Technical Note

Project No: ITB13091
Project Title: Ford Airfield – The Landings
Title: Sustainable Accessibility Addendum Note
Ref: 13091-029
Date: 5 August 2020

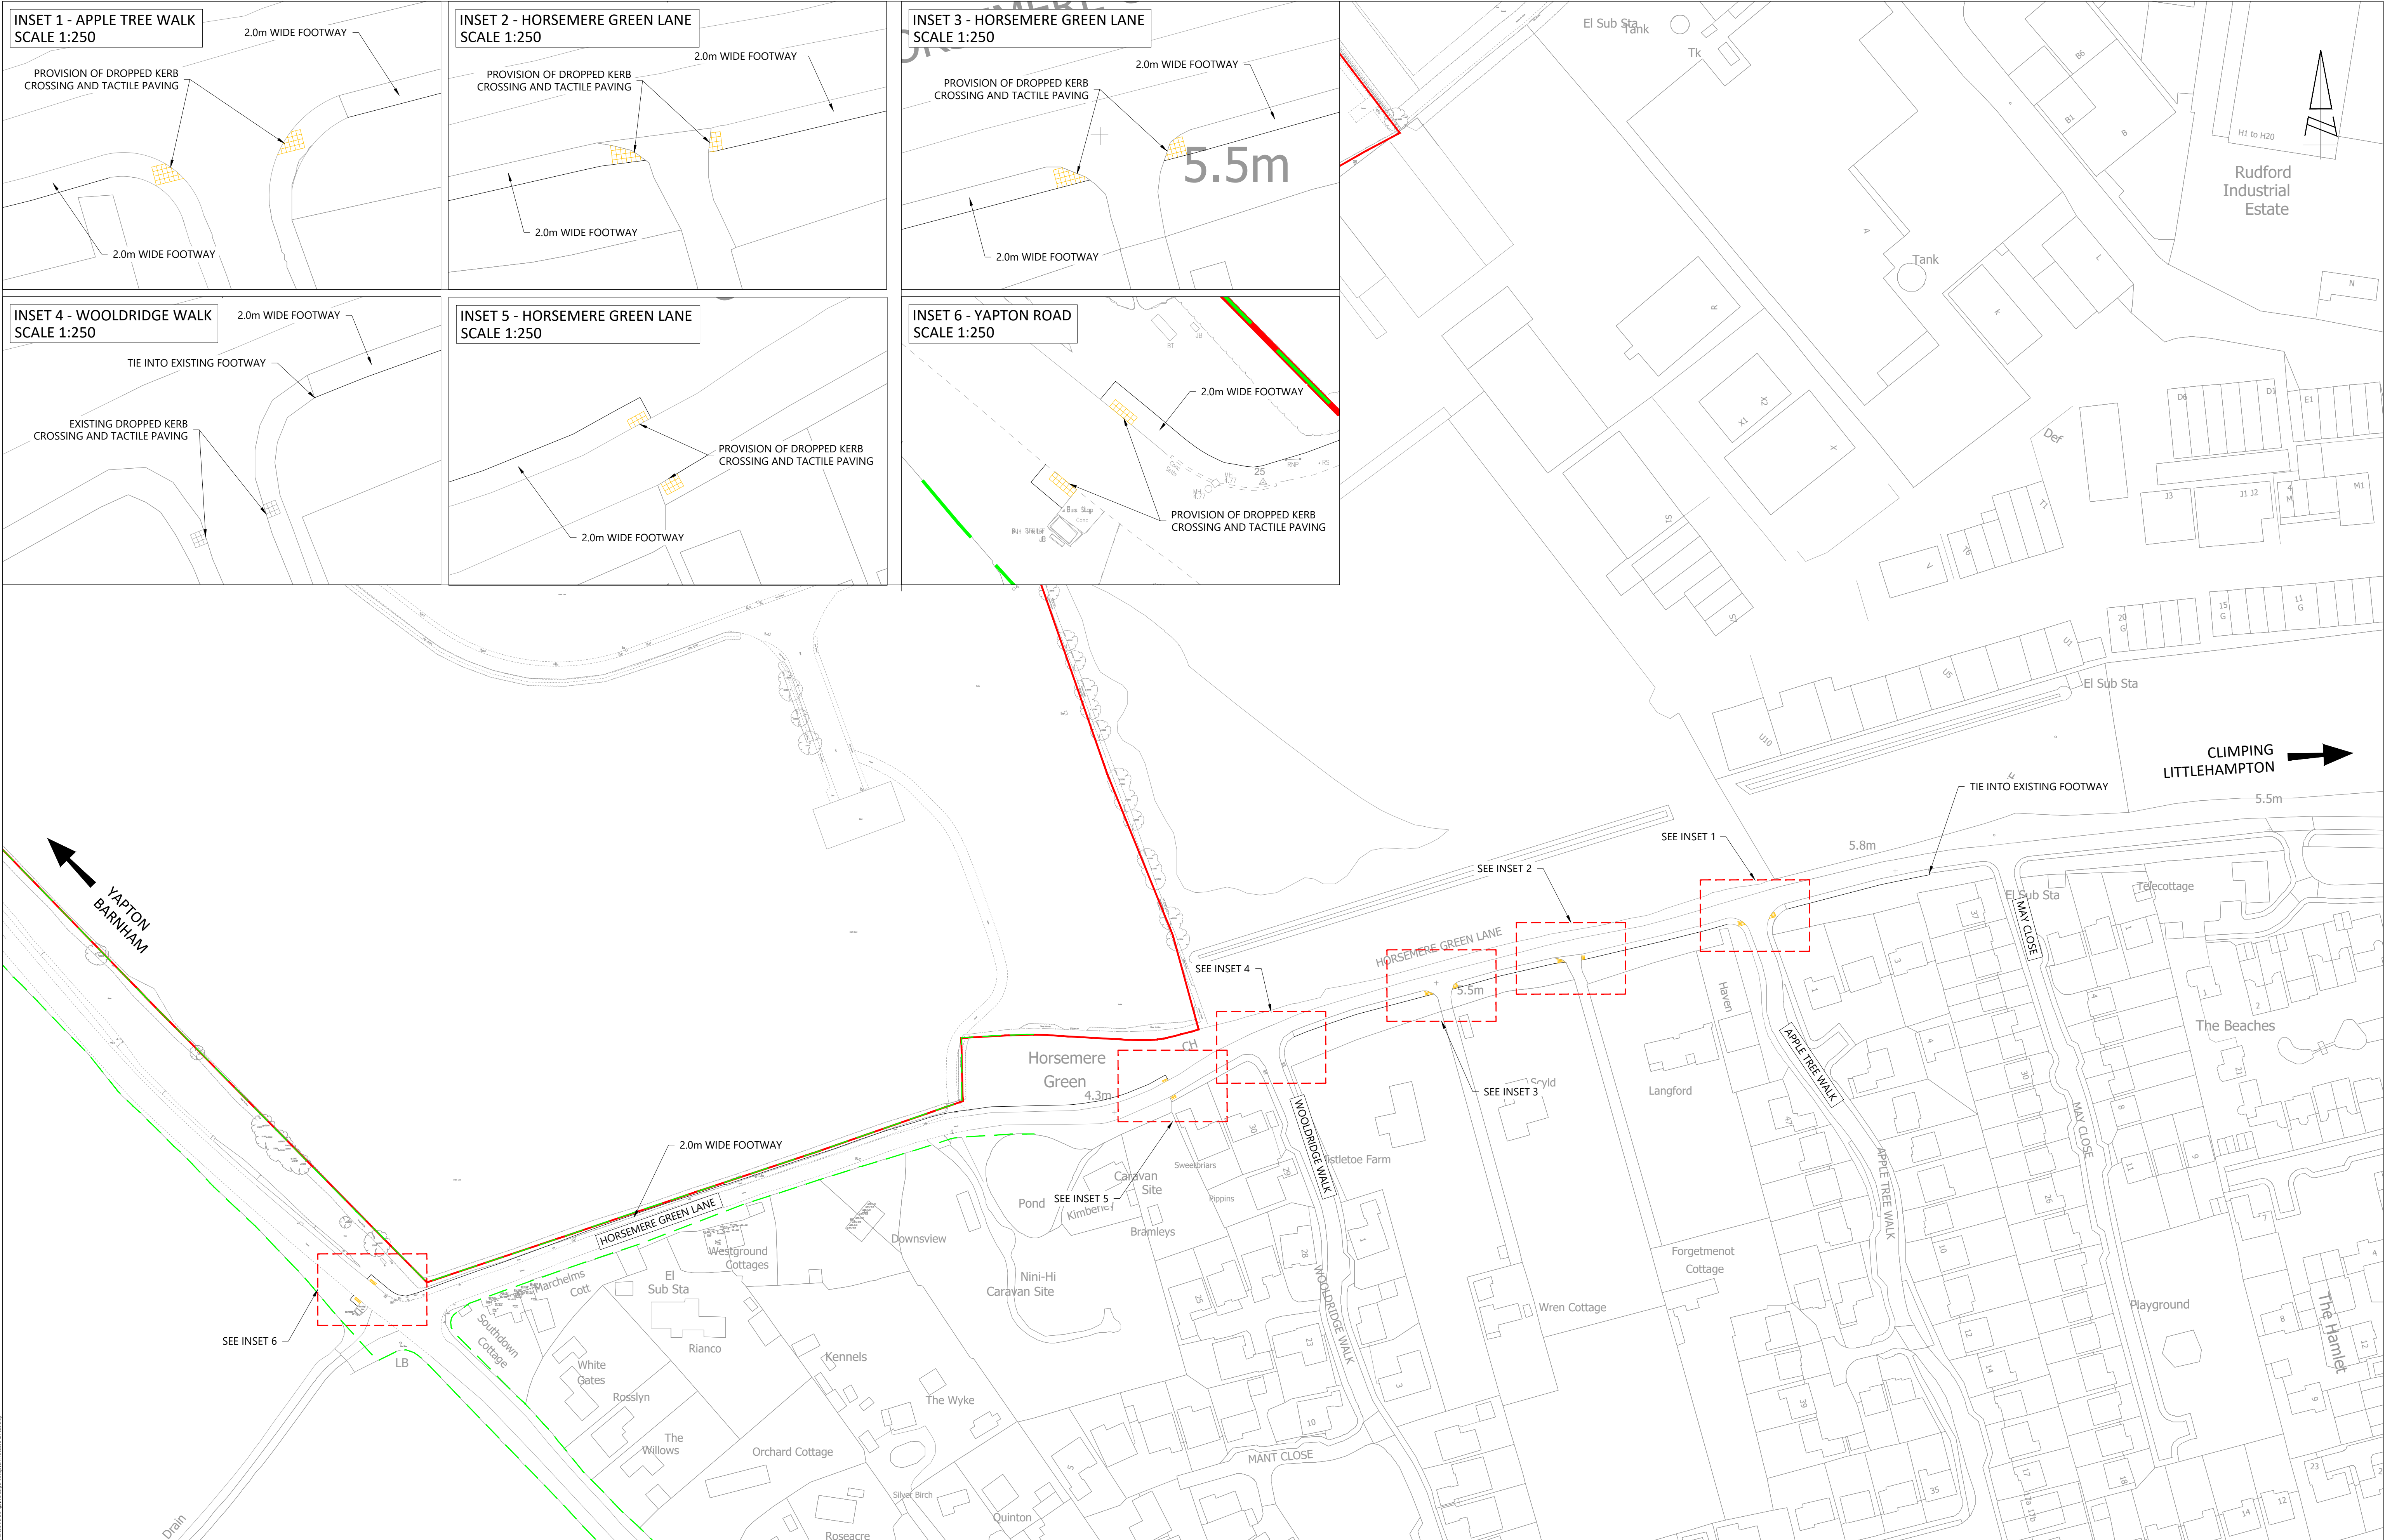
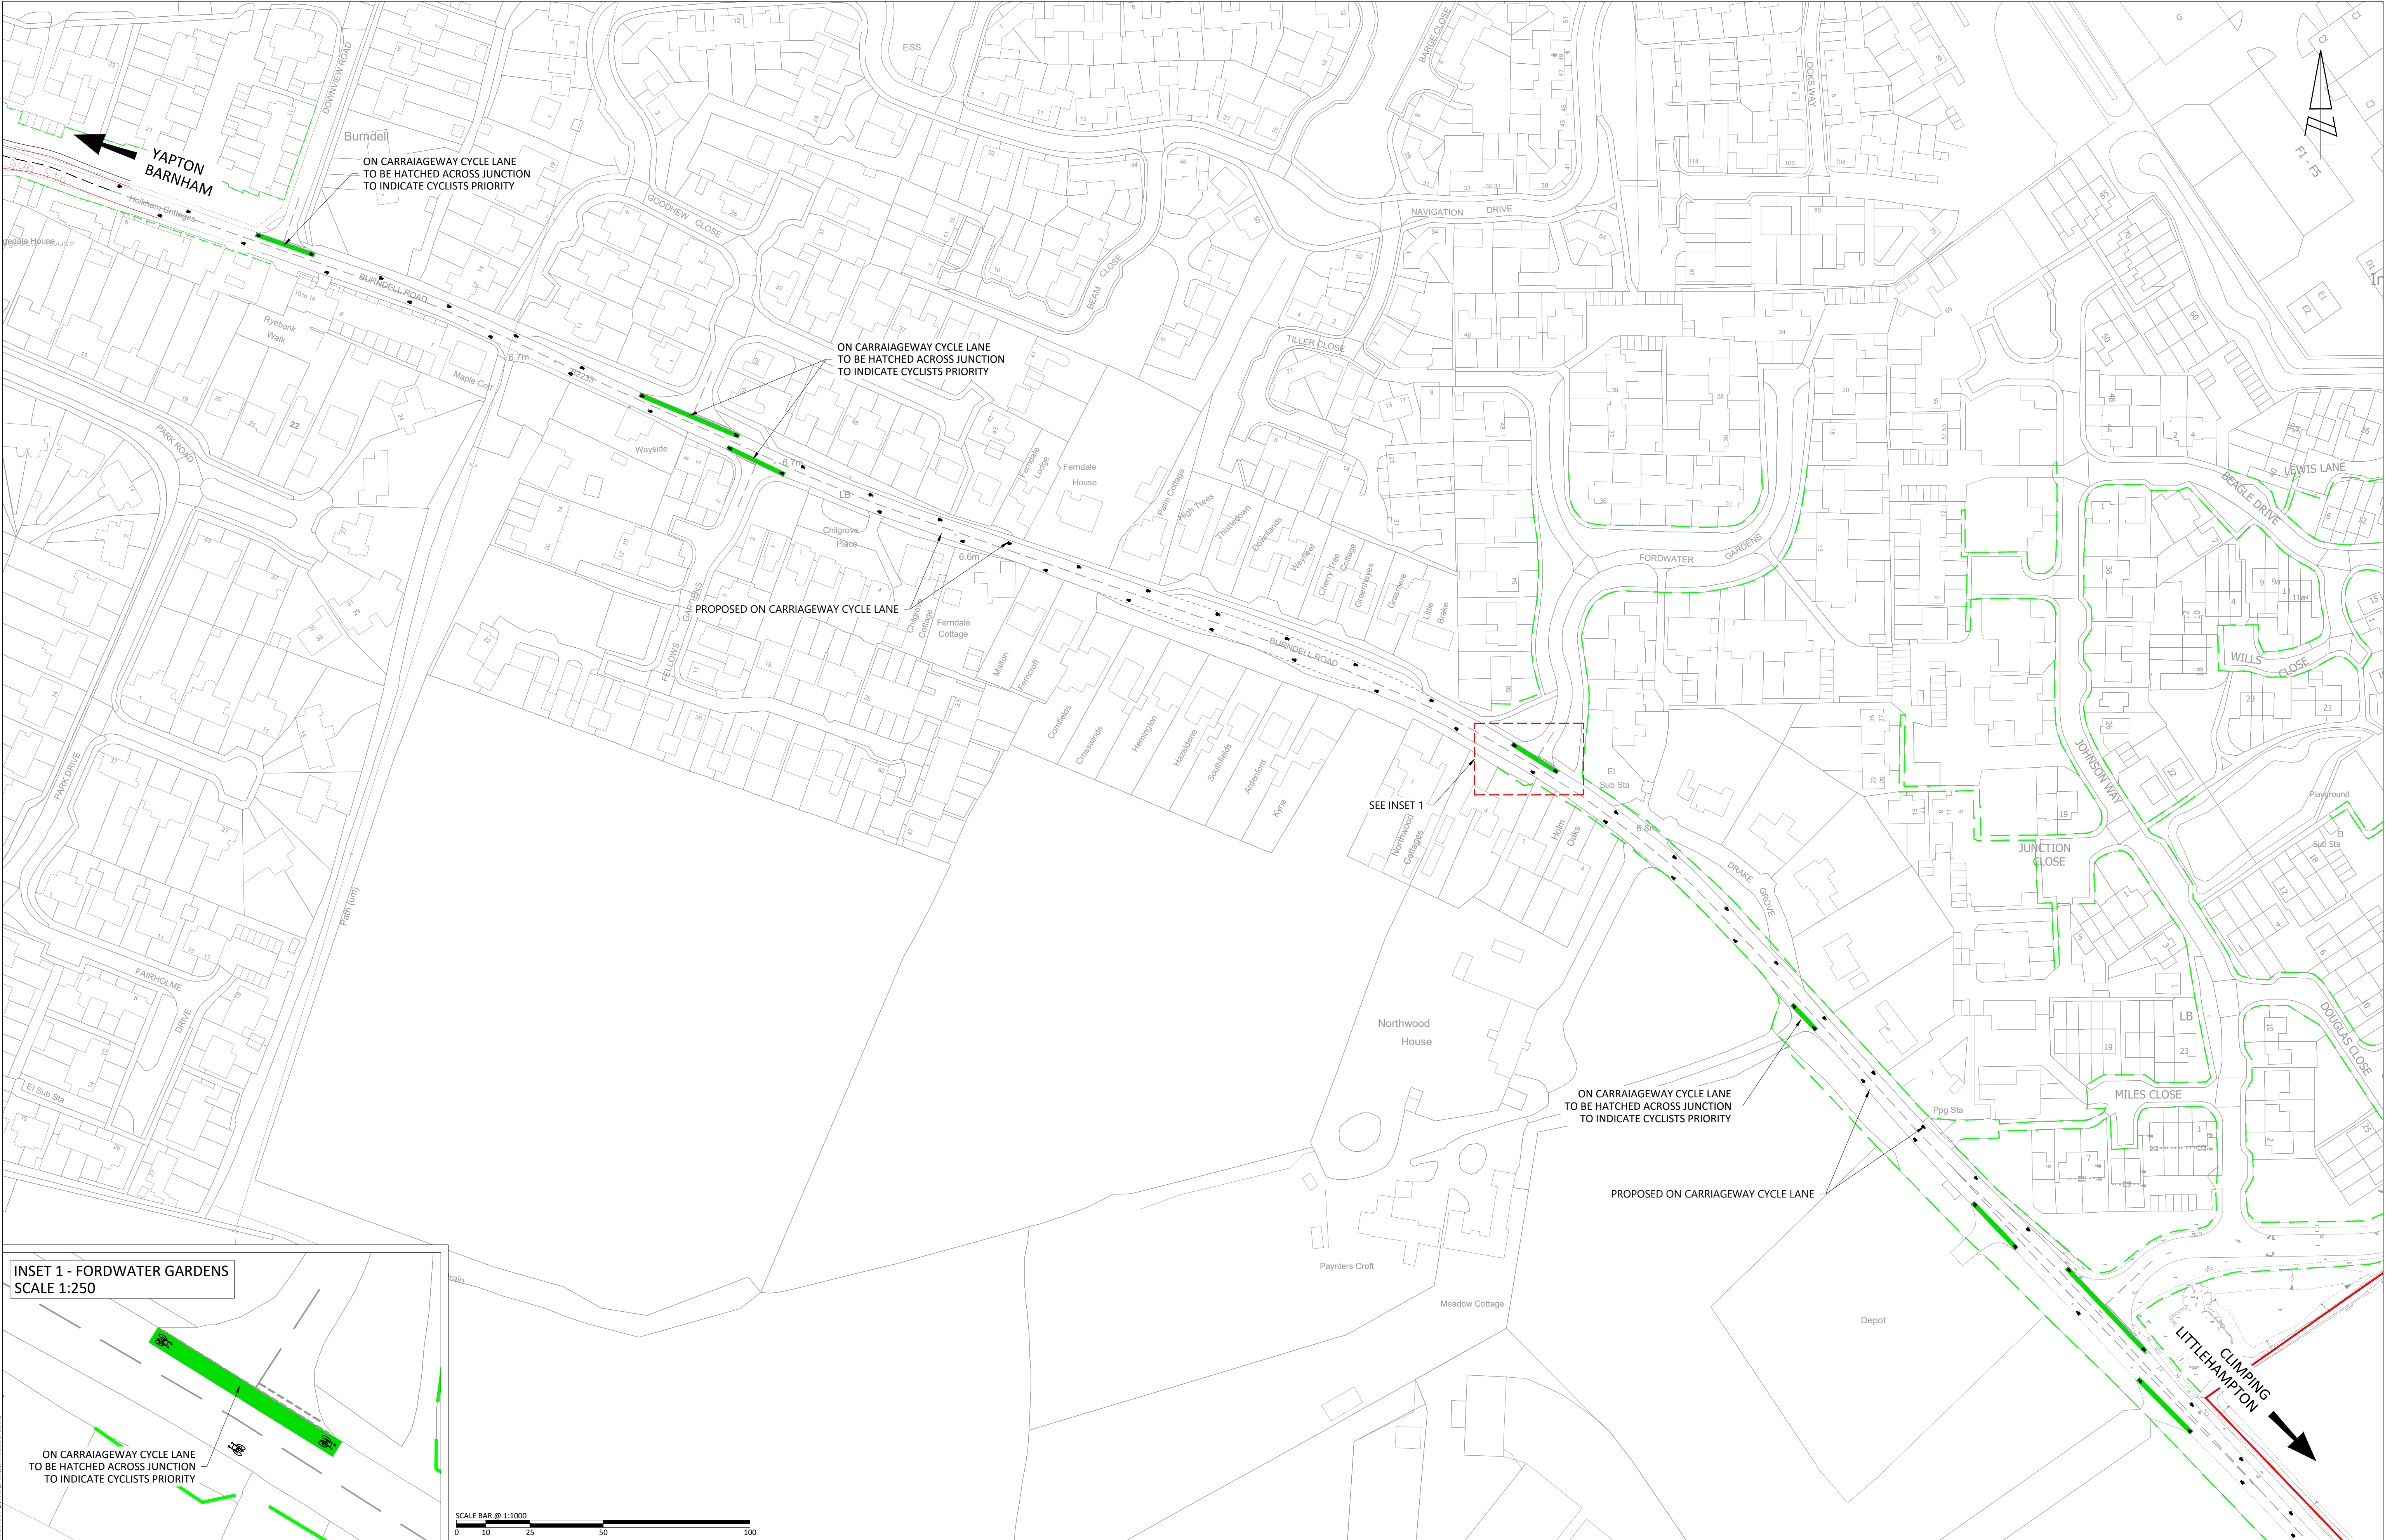
- 3.1.1 WSCC has requested that further consideration be given to provision of cycle facilities between the development site and Yapton.
- 3.1.2 It is not possible to provide an off-road route along the B2233 due to width constraints along the corridor as a result of private property being located on both side of the road. As recognised in Chapter 3 of the CDG, it is recognised that it will not always be possible to retrofit new infrastructure into the existing highway network in accordance with the design guidance contained within the document due to such constraints. The CDG advises that, in such instances, the design should be considered on a site-specific basis.

- 3.1.3 The B2233 is subject to the carriage of buses services and therefore it is necessary to retain a carriageway width of at least 6m in order to effectively accommodate these services; in doing so, it would only be possible to provide cycle lanes circa 1m in width. Table 2a of the CDG sets out that a width of 1.7m would be required to provide for an absolute minimum effective width of 1.5m. In such circumstances, the CDG advises that where the minimum width cannot be attained over the majority of its length then cycle lanes should not be provided. Alternatively, cycle signage and demarcation should be used.

- 3.1.4 On this basis, a scheme of improvements has been prepared and are shown in **Drawings ITB13091-GA-059, 060 and 061**. The scheme comprises signage of a cycle route to Yapton from Rollaston Park with on-carriageway cycle logo demarcation situated 1.5m from the kerb at 25m intervals. In addition, green coloured surfacing is provided across junctions to reinforce the potential presence of cyclists and minimise the risk of conflict arising from vehicles overshooting the give-way line/creeping into the carriageway from a side road.

- 3.1.5 The scheme of improvements has been shown to extend from Rollaston Park in the east to Yapton Village Hall in the west, directly west of the Bilsham Road/B2233 mini roundabout. In addition, the route extends south from the Bilsham Road/B2233 mini roundabout to Mill View Road to provide a connection to potential onwards facilities secured through planning consents Y/91/17 and Y/92/17.
